**Transport
for NSW**

**Section 75W Modification Application (MP08_0241 MOD 5)
86-96 and 100 Mount Street, North Sydney**

TfNSW has reviewed the supporting documentation and comments are provided in relation to Railway Infrastructure Contribution, Active Transport and Construction Traffic Management at **TAB A** for consideration in the assessment of the application and in drafting of conditions.

1 Level B5
SCALE: 1 : 100

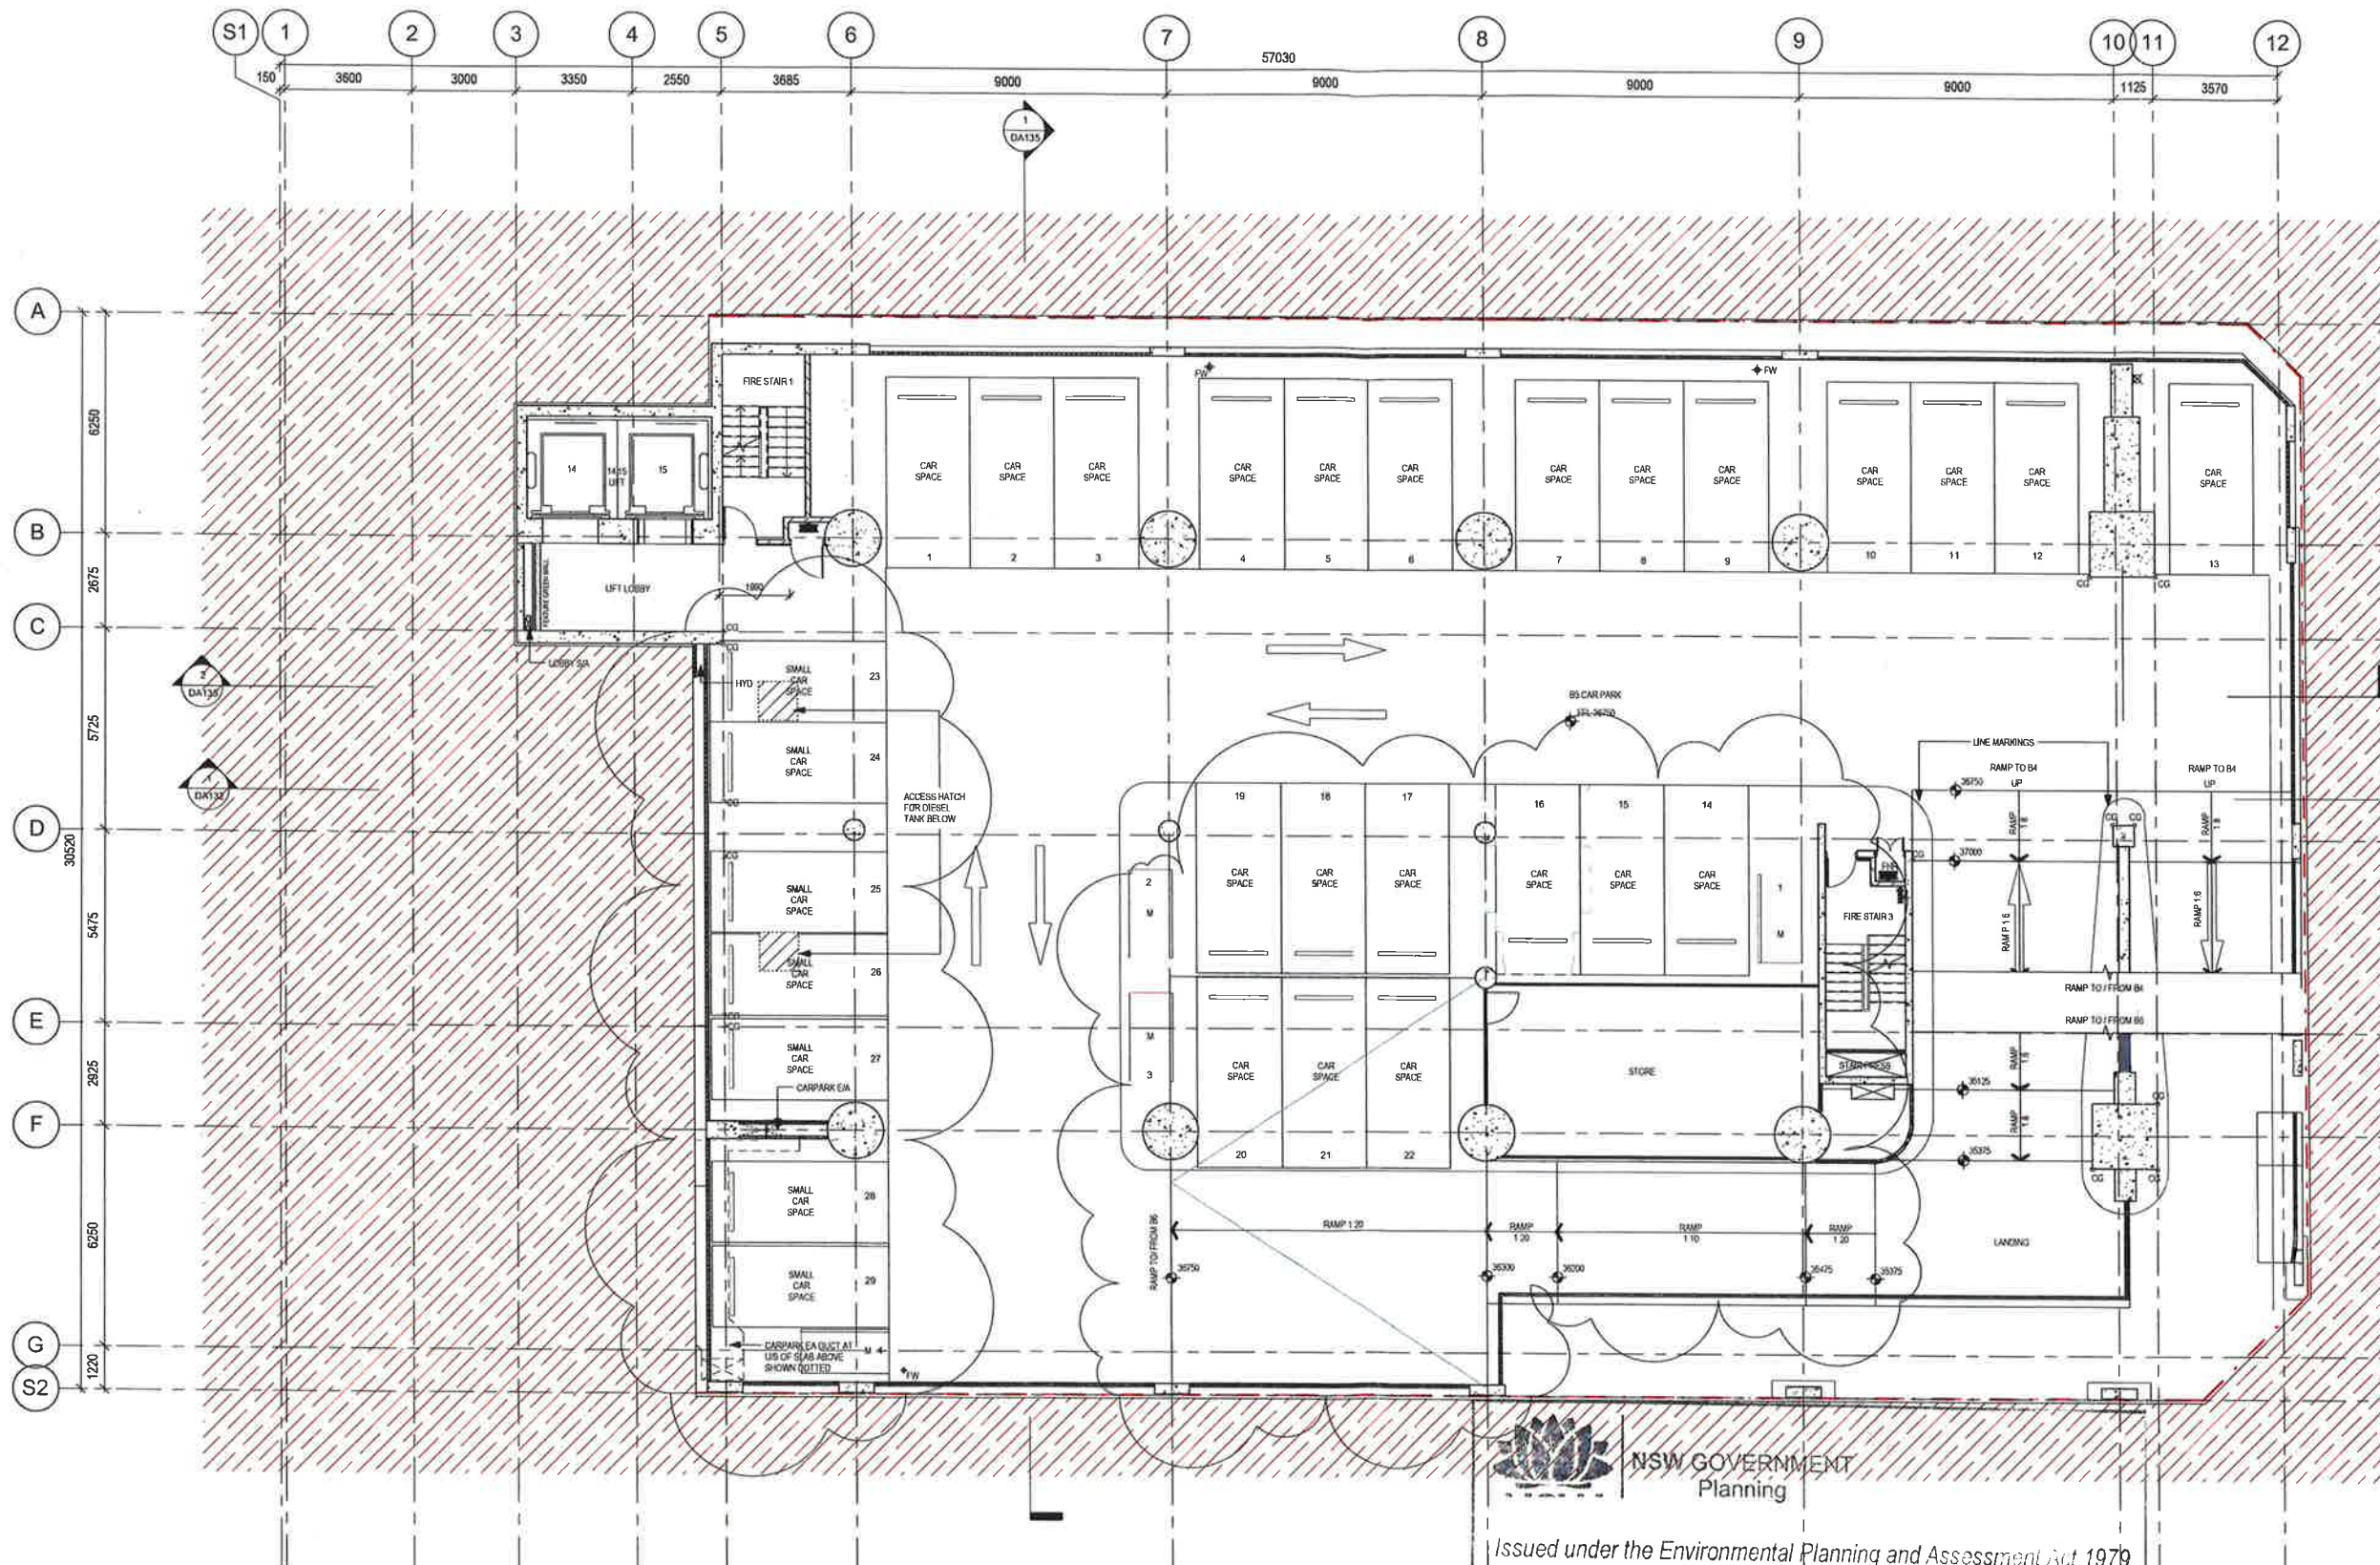
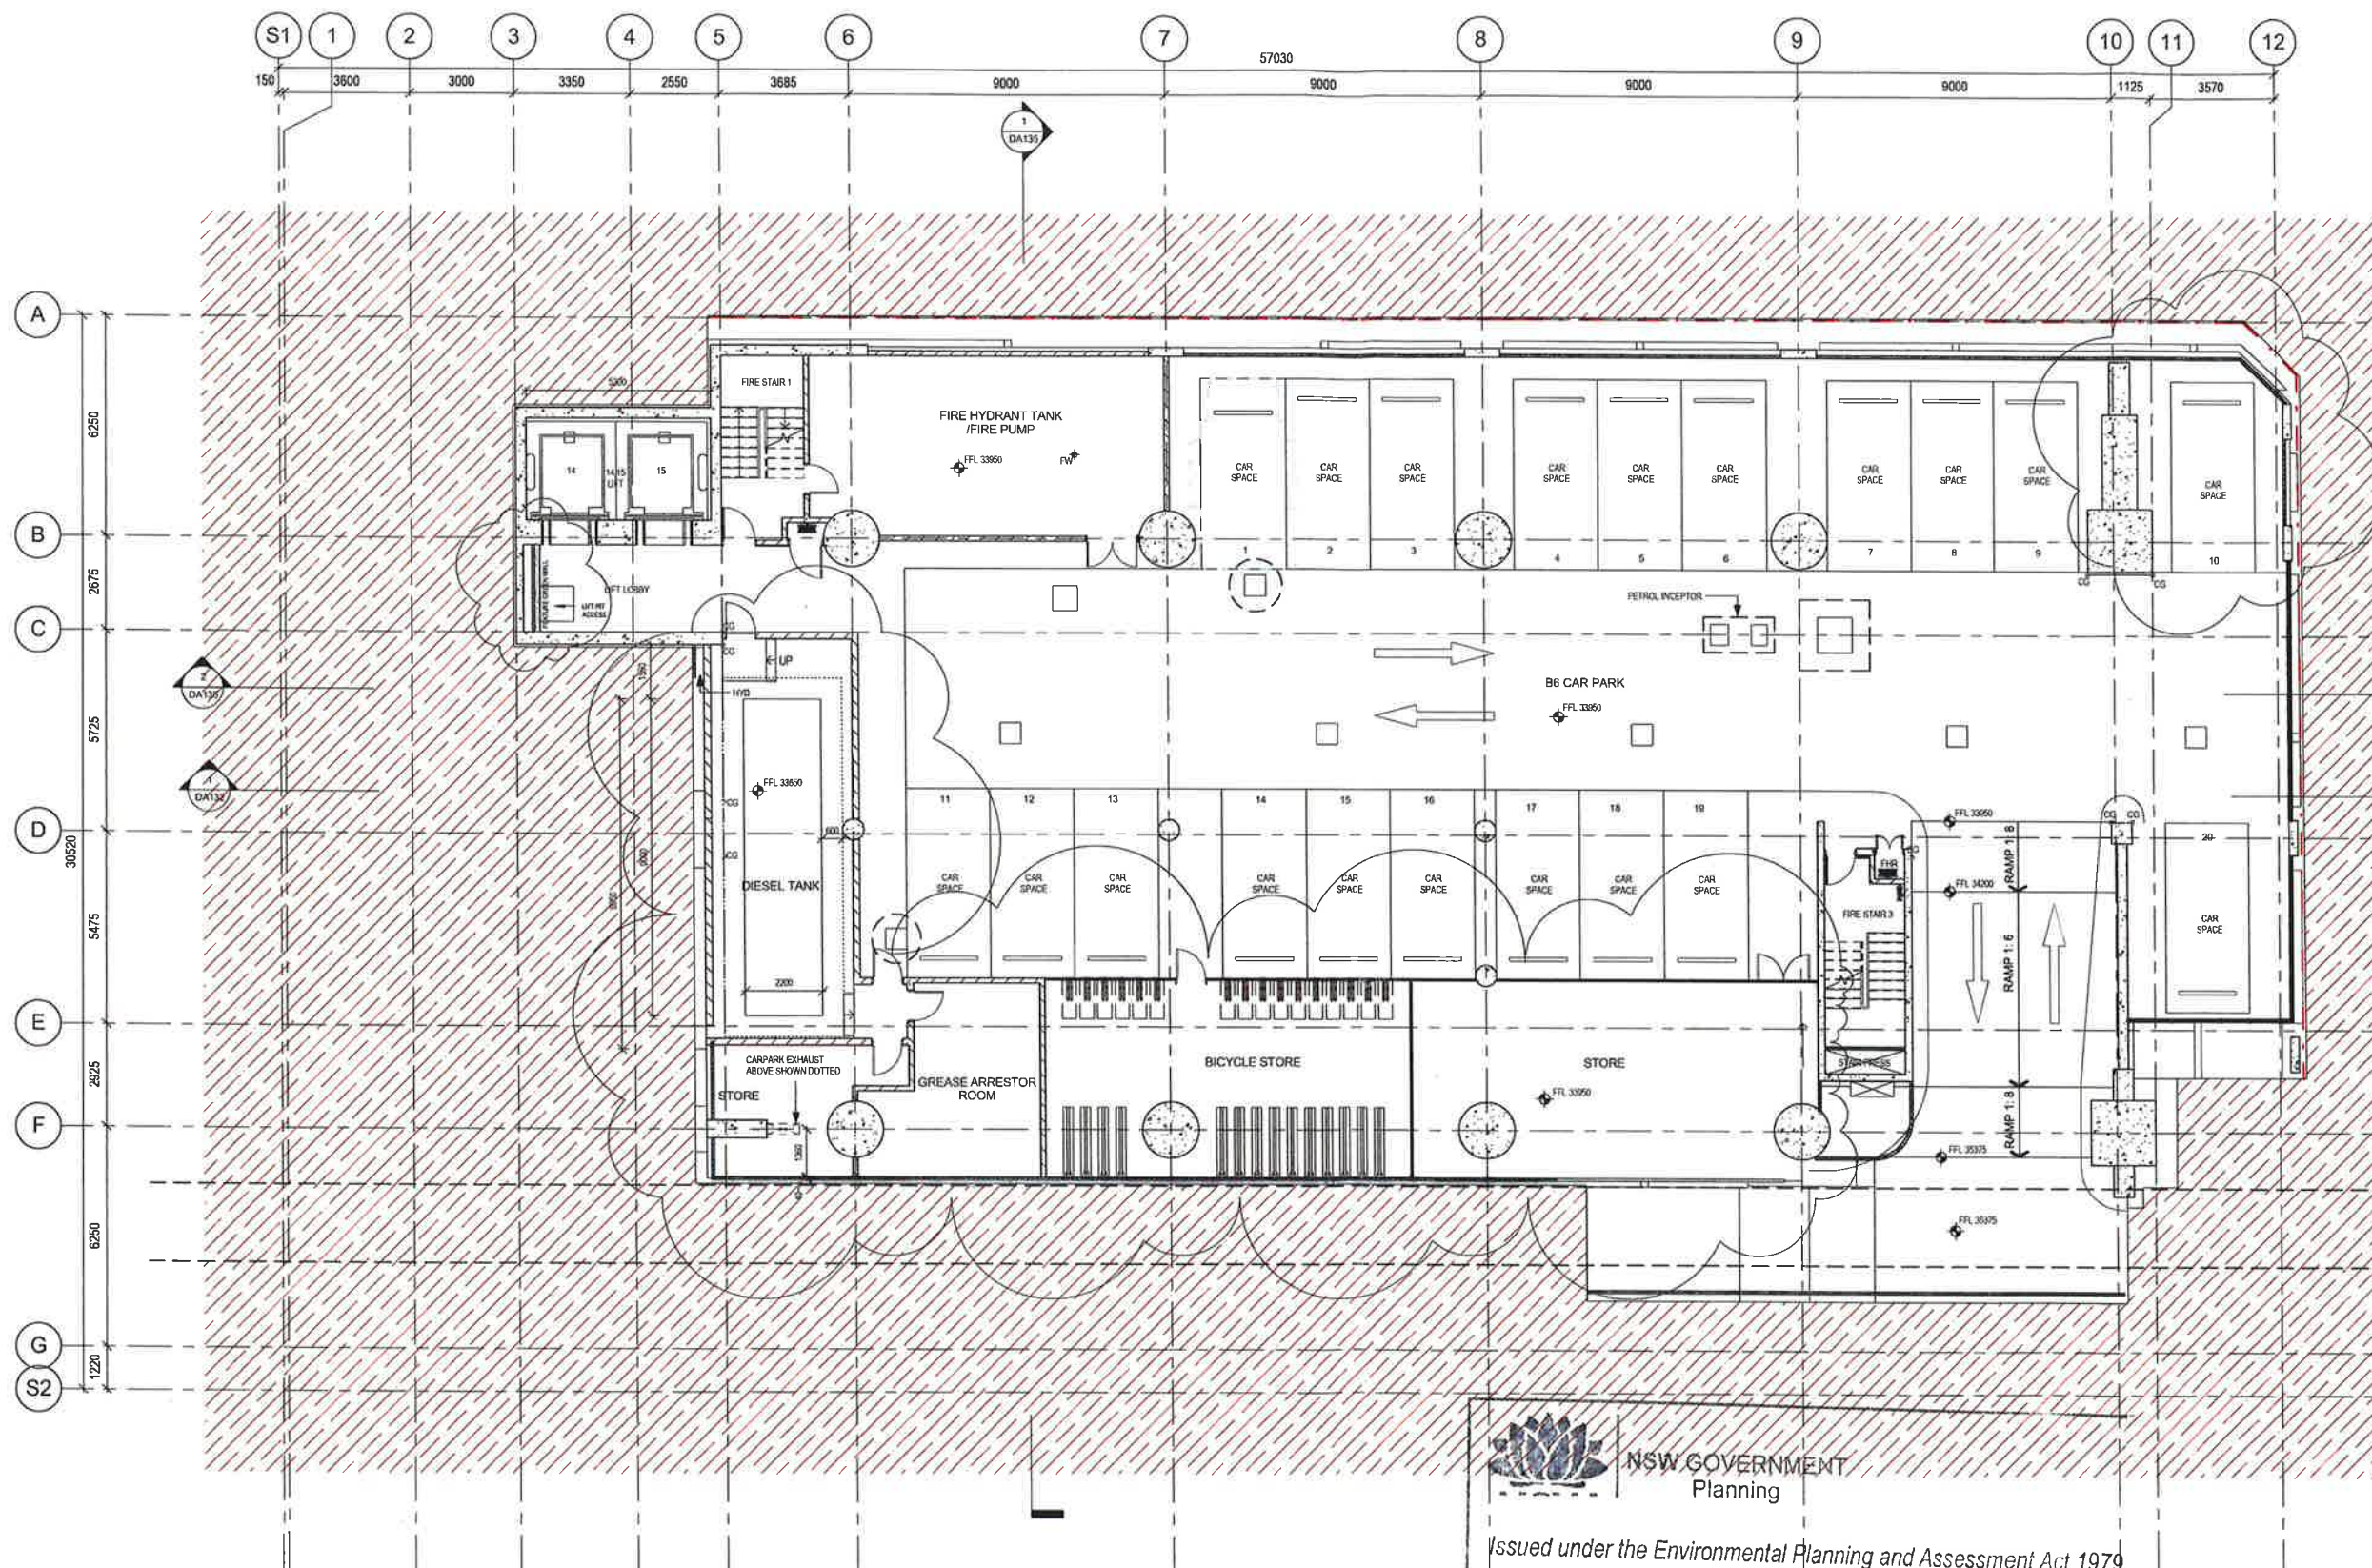
The proposal results in a loss of 96 bicycle parking spaces. Bicycle parking should be provided in accordance with North Sydney DCP requirements.
